Re: Armar Road Townhomes – *Technical Review 1*
PA22047

RE: Armar Road Townhomes, File# PA22-047
17 unit townhome development
6506 Armar Road & Parcel # 30052800402700

To: Elden McCall, Mac Engineering
From: Don McGhee, Assistant Fire Marshal
Date: March 23, 2023
Subject: PA22-047 6506 Armar Rd. Townhomes

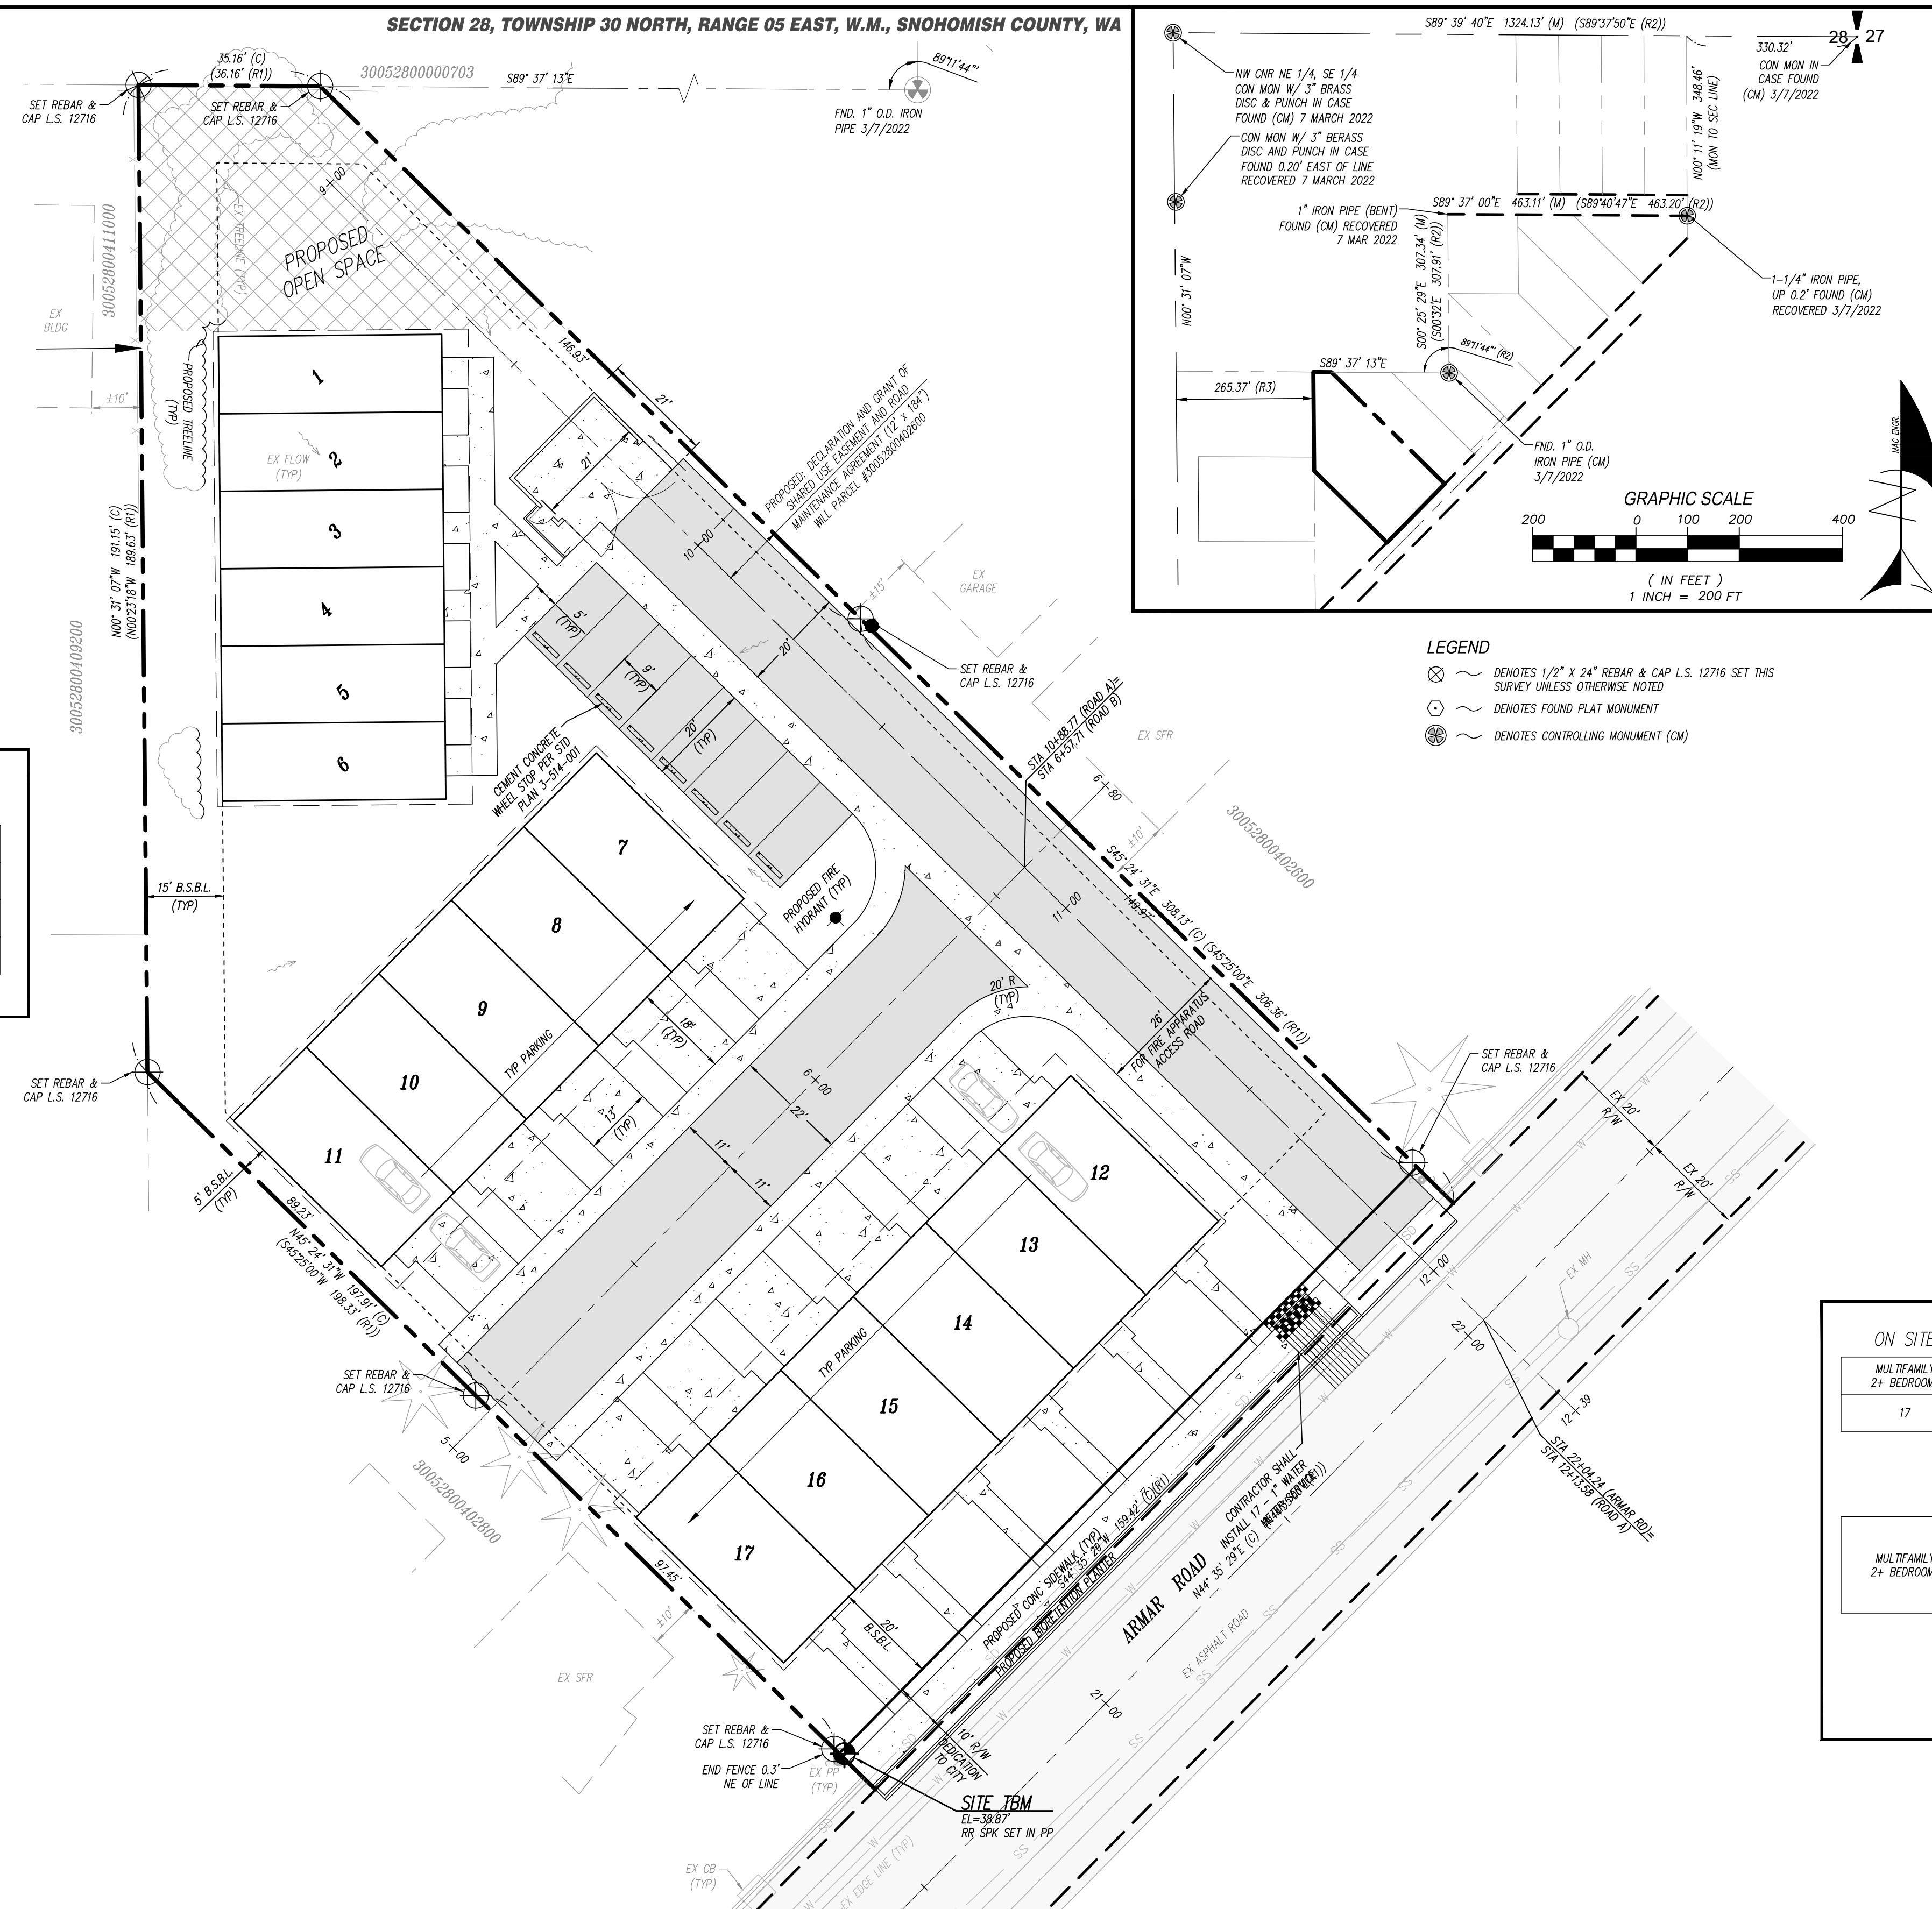
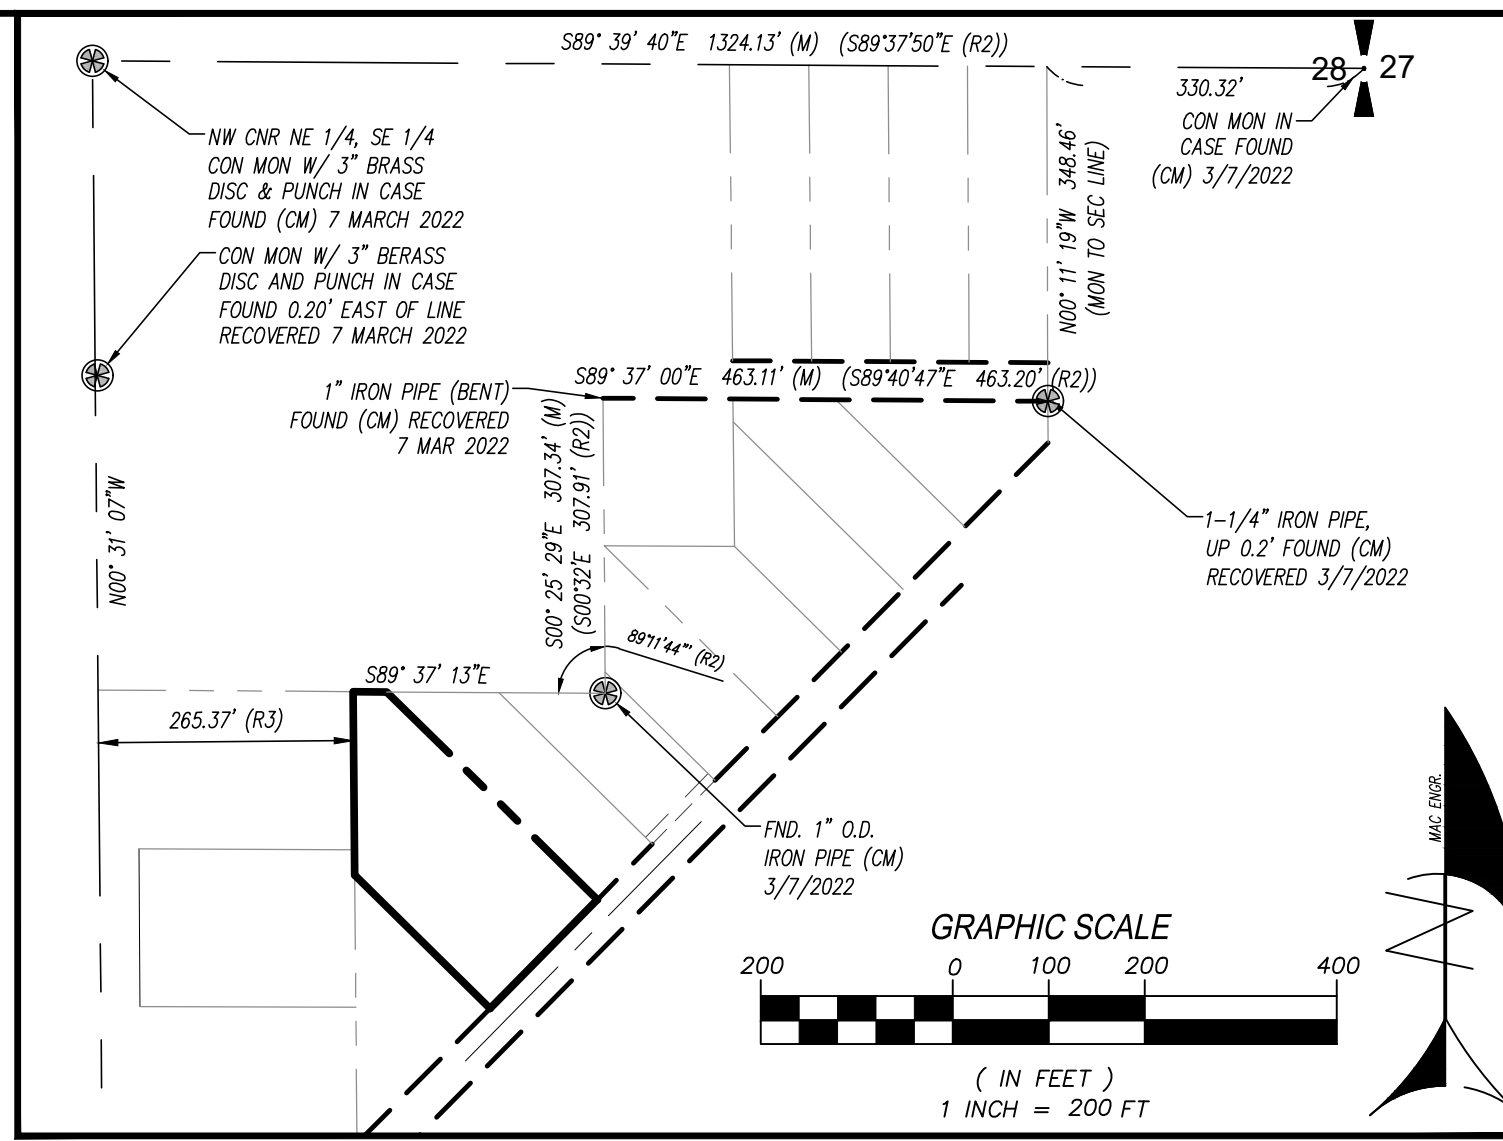
1. Reference File No. PA22047 on all future, site, civil and landscape plan submittals.
2. Provide a Traffic Impact Analysis.
3. Amend Sheet P1.0 *Preliminary Site Plan* to include the following information:

- a. Density calculations. The maximum base density is 18 du/acre and no maximum density (using Residential Density Incentives);
 - b. Dimensional standards as outlined in MMC 22C.080.140(2);

- c. Provide bicycle parking calculations and locations in accordance with MMC 22C.130.060.
4. Provide color elevation drawings, including proposed construction materials, so staff can review for compliance with the applicable design standards outlined in MMC Chapter 22C.080.

5. Units 12-17 shall be oriented towards Armar Road, with front entry and windows facing Armar.
6. A decorative garage door complementing the architecture of the buildings shall be required.

8. Please provide detailed open space calculations and amenity specifications, in accordance with [MMC 22C.080.420](#). This should include amount of common and private open space per unit, and identification of open space on site plan. Please note that required setbacks shall NOT count as common internal open space.
